OFFICIAL NOTICE OF DECISION

CITY OF ALBUQUERQUE
PLANNING DEPARTMENT
DEVELOPMENT REVIEW BOARD

Project# 1004233

WESTLAND DEVELOPMENT CO LP request(s) the above action(s) for all or a portion of **STORMCLOUD Unit(s) 1, 2, & 3**, zoned RLT, located on TIERRA PINTADA BLVD NW BETWEEN ARROYO VISTA BLVD NW AND ARKANSAS RD NW containing approximately 107 acre(s). (J-08, 09 & H-08, 09)

Plat of
Stormcloud
Subdivision Unit 3
Albuquerque, Bernalillo County, New Mexico
August 2006

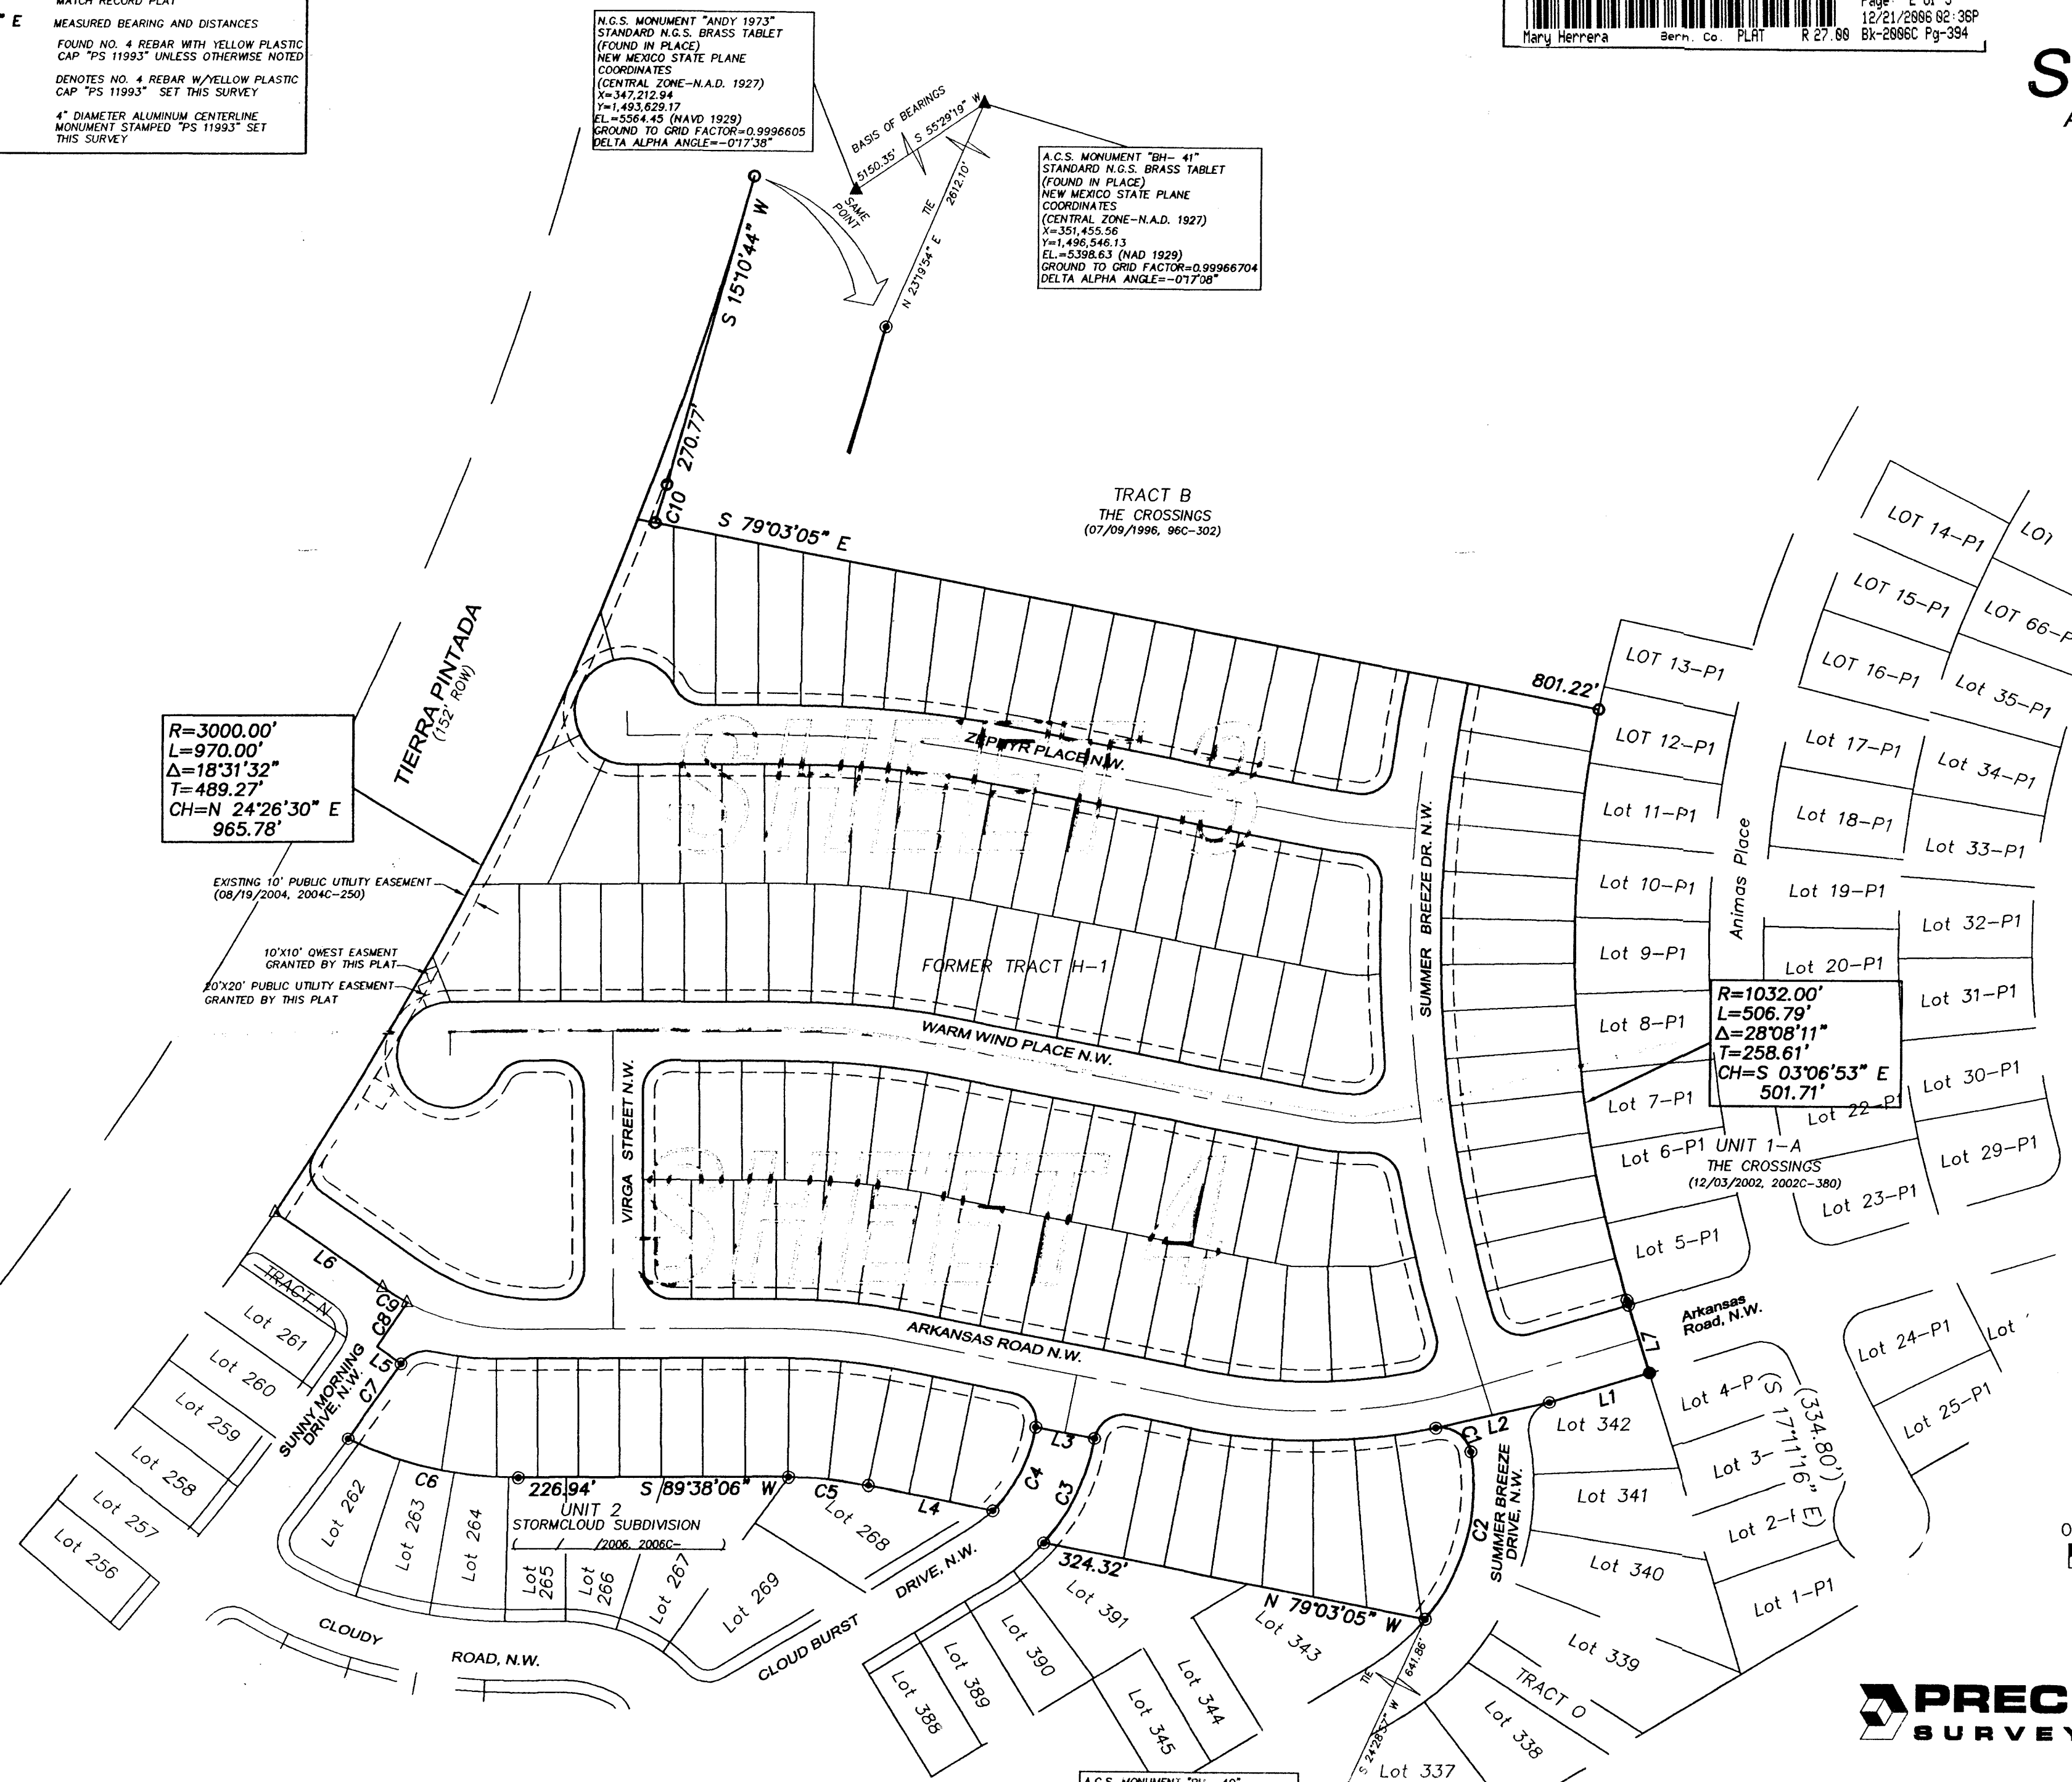
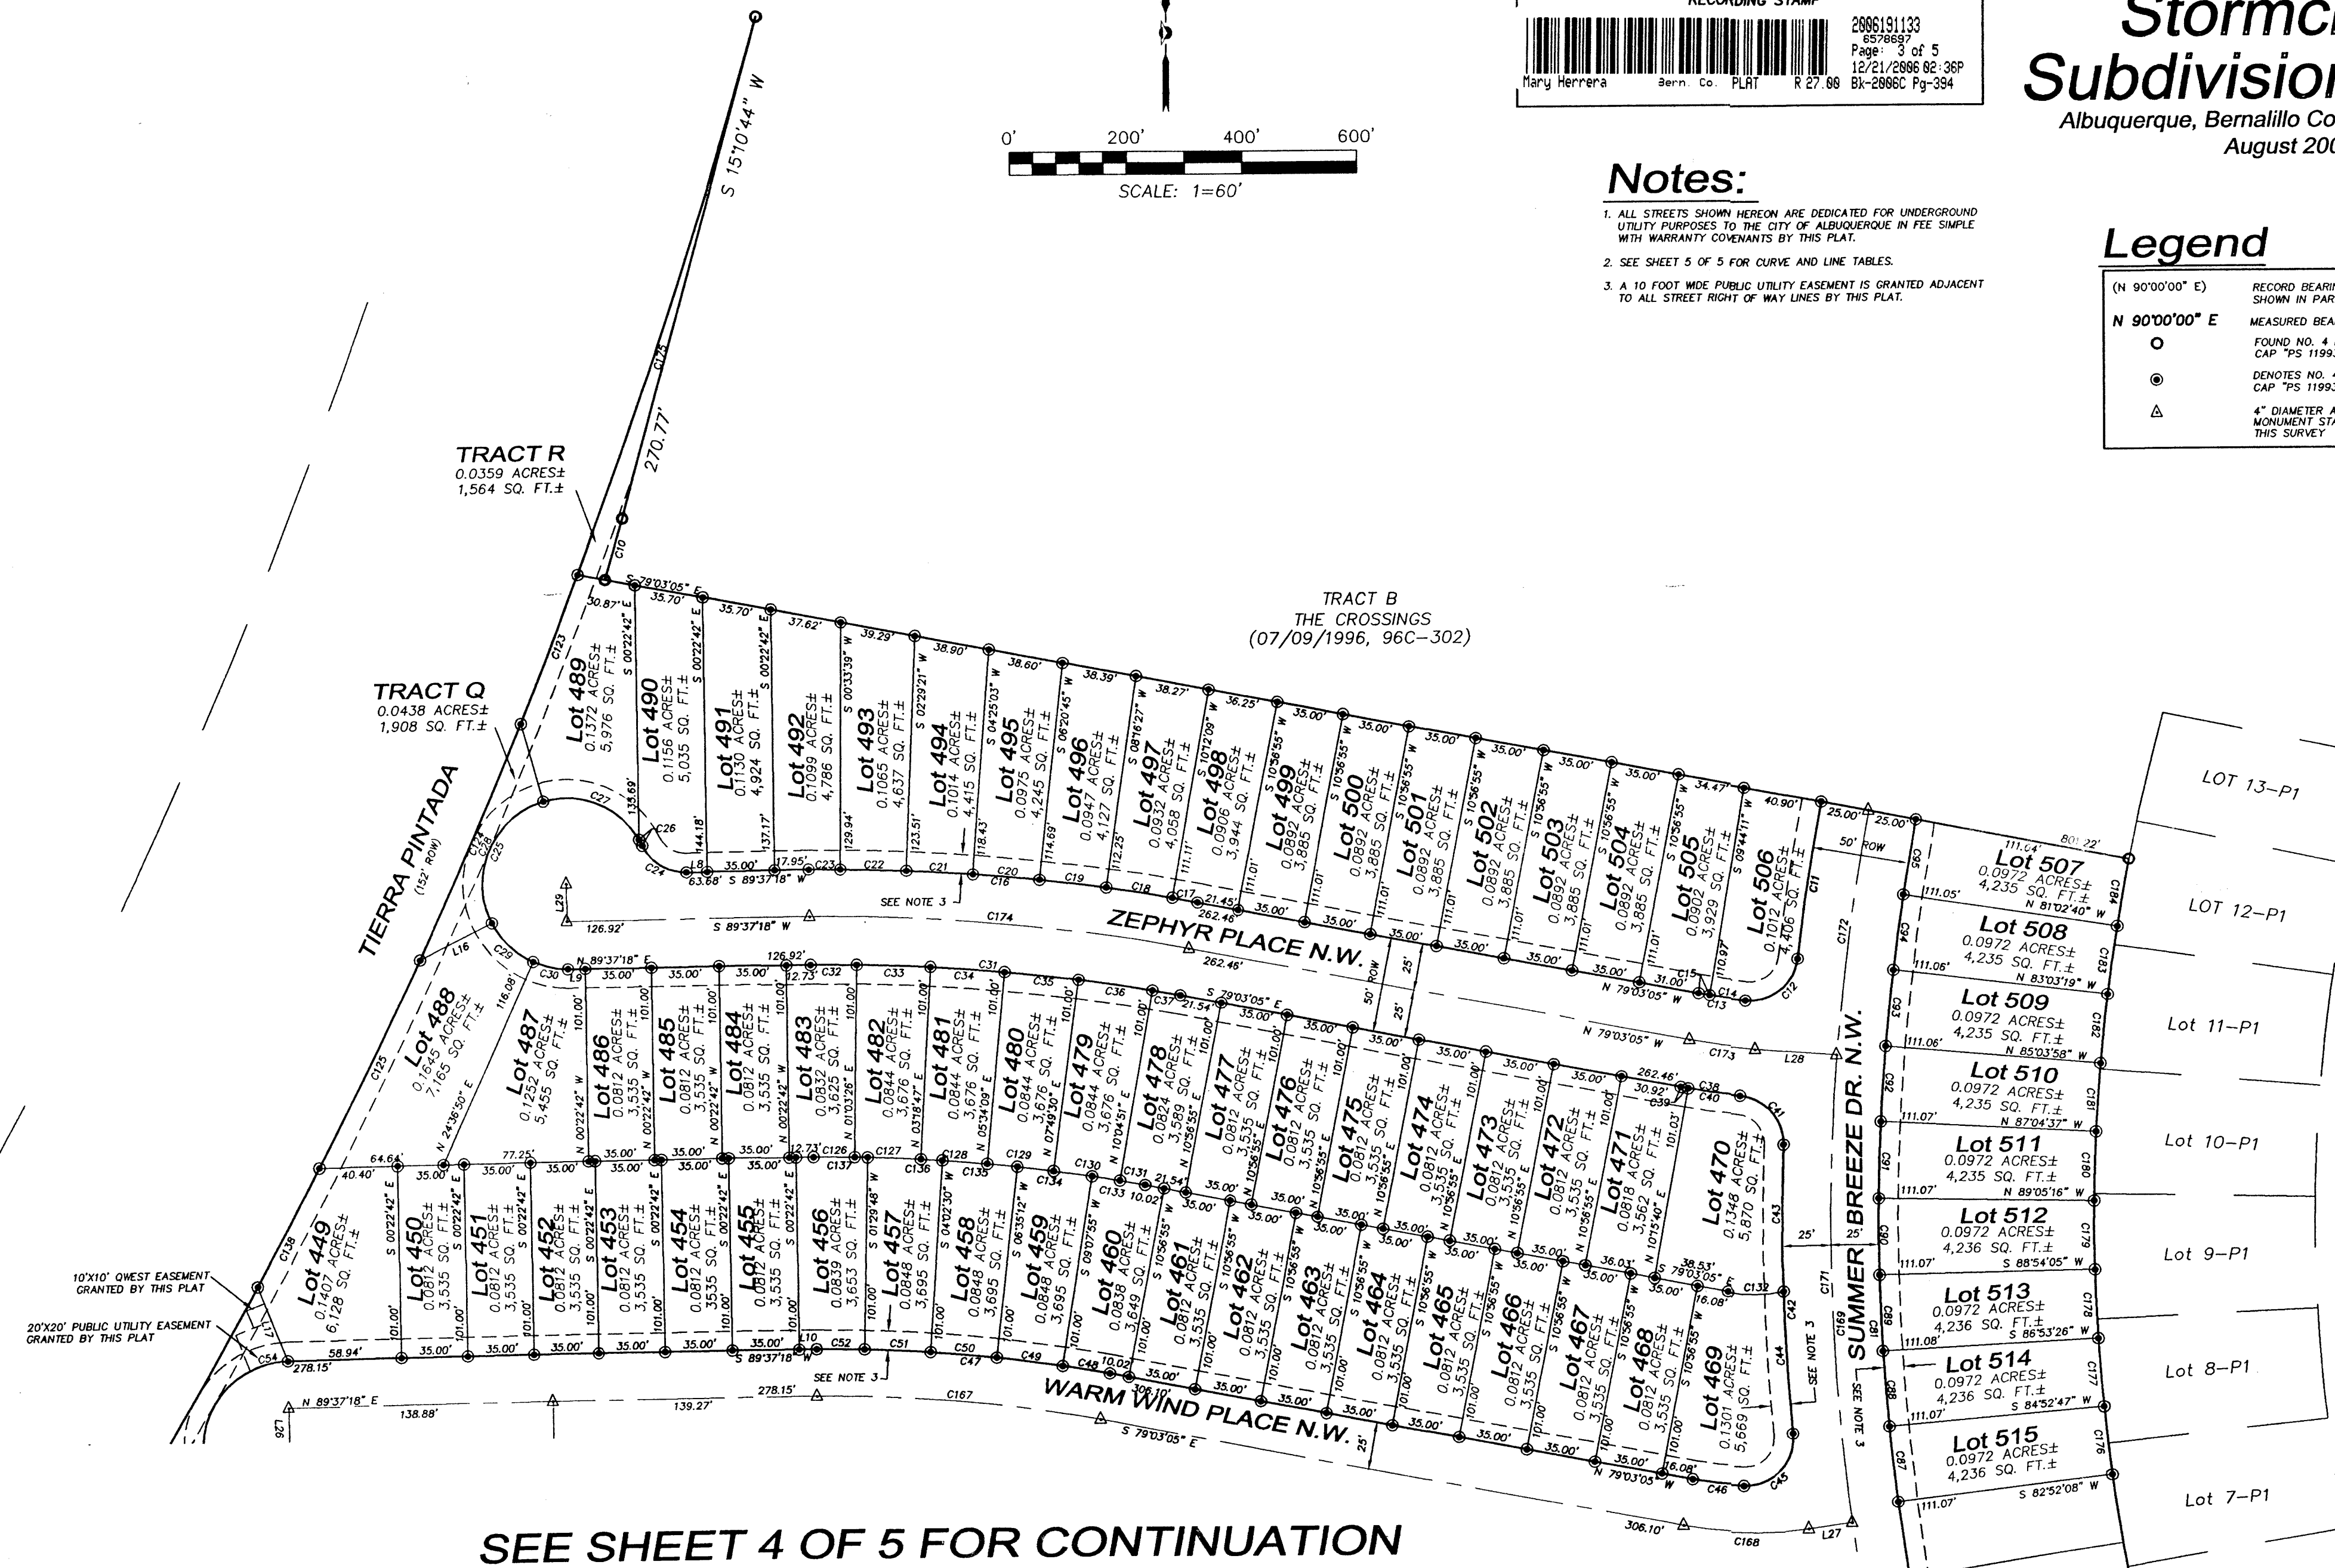
TRANSPORTATION: M: B of tracts
 W, SAS, SD esmt on tract Q
 Master plan study

PLANNING (Last to sign): AMAFCA's Signature
 Record
 StormCloud 2 should be recorded 1st.

AMAFCA must sign plat prior to City Engineer.
Need a storm drain easement on Tract Q.
Provide maintenance and beneficiary information for all tracts.
